June 13, 2024

**Re: Eagle Ranch Retail
9641 Eagle Ranch NW
Traffic Circulation Layout
Engineer's/Architect's Stamp 3-5-24 (B13D002C)**

Based upon the information provided in your submittal received 6-12-24, the above referenced plan cannot be approved for Building Permit until the following comments are addressed:

AS-1.0

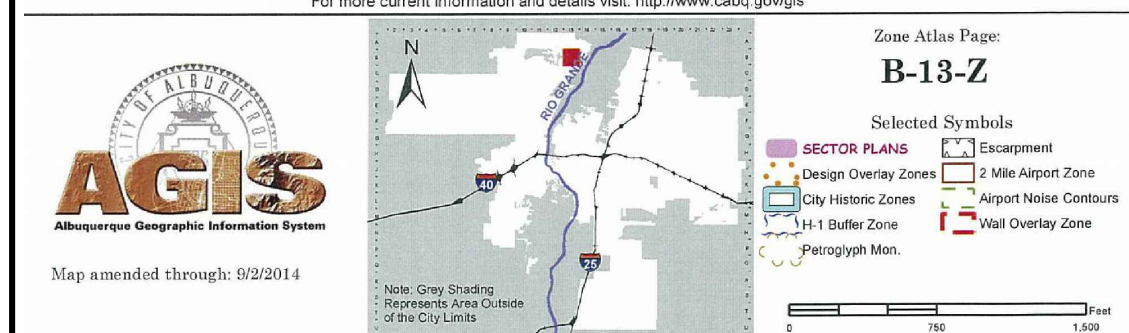
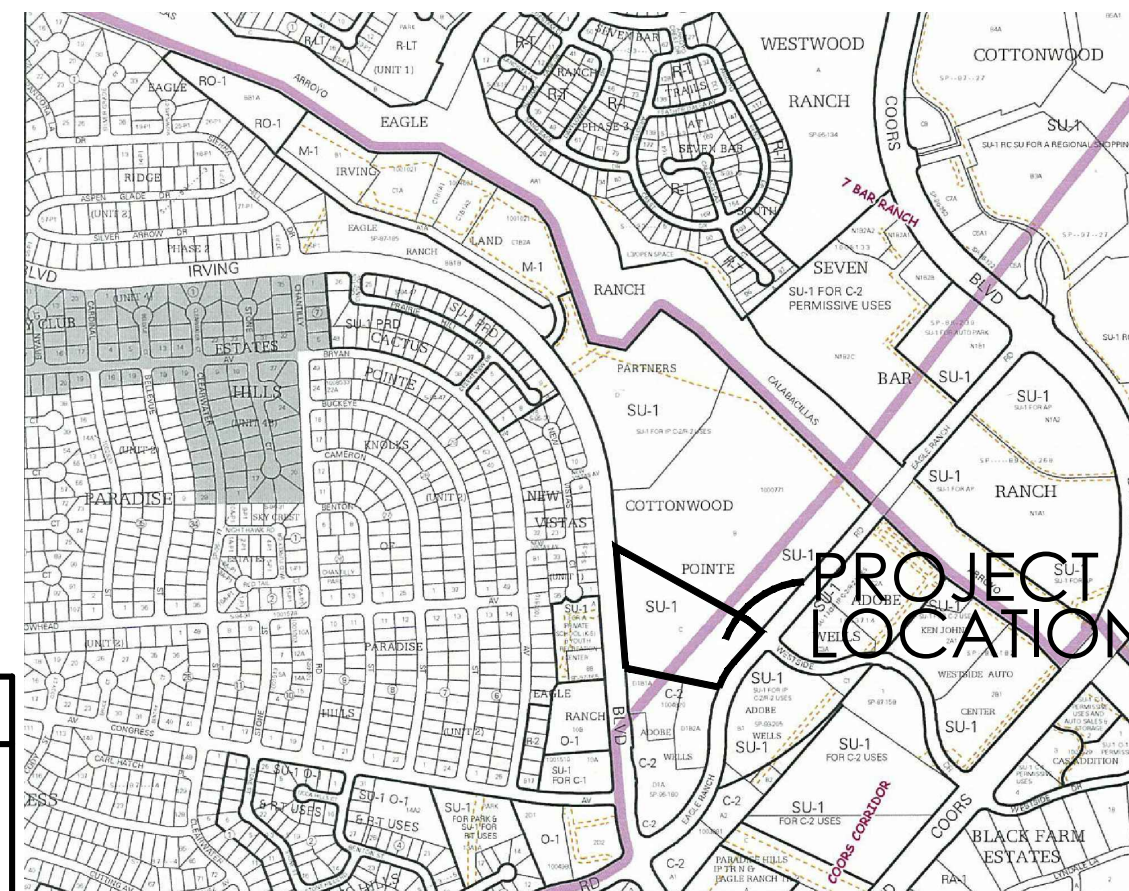
1. Mark the project location on the vicinity map, and add the missing symbols to Legend.

2. List the number of parking spaces required by the IDO as well as the proposed number of parking spaces including bicycle and motorcycle parking correctly.

ACES
= 28.12 (29) SPACES
NMBC TABLE 1106.1 2
2018 IDO TABLE 5-5-
26-50 = 2 SPACES
= 53 TOTAL SPACES PRC
= 10% OF TOTAL PROVID
= 5.3 (6) BIKE SPACES

413
RETAIL
7,200 S.F. FO
29 SPACES REQ.
72 SPACES PROV.
BUILDING HT. 24'-0"

11. BIKE RACK FOR (5) BICYCLES, F
A. 30" TALL x 18" WIDE.,
B. BICYCLE FRAME SHALL BE SU

3. Please, draw a line for boundary of Phase 2. Your parking calculation is only for this phase (Building A). Hatch all the parking spaces that are not part of this phase 2.
4. ADA curb ramps must be updated to current standards and have truncated domes installed.
5. Minimum drive through stacking spaces is 12. Modify your drive through design to accommodate for 12 cars. Keyed note 39 is not acceptable.
6. Submit documentations on keyed note 28 and on the following note at the bottom of the sheet

SIDEWALK TO BE
CONSTRUCTED FOR NMDMV
SIDEWALK TO BE DEFERRED FOR
CONSTRUCTION UNTIL RETAIL AND
PHASE II CONSTRUCTION
COMPLETED
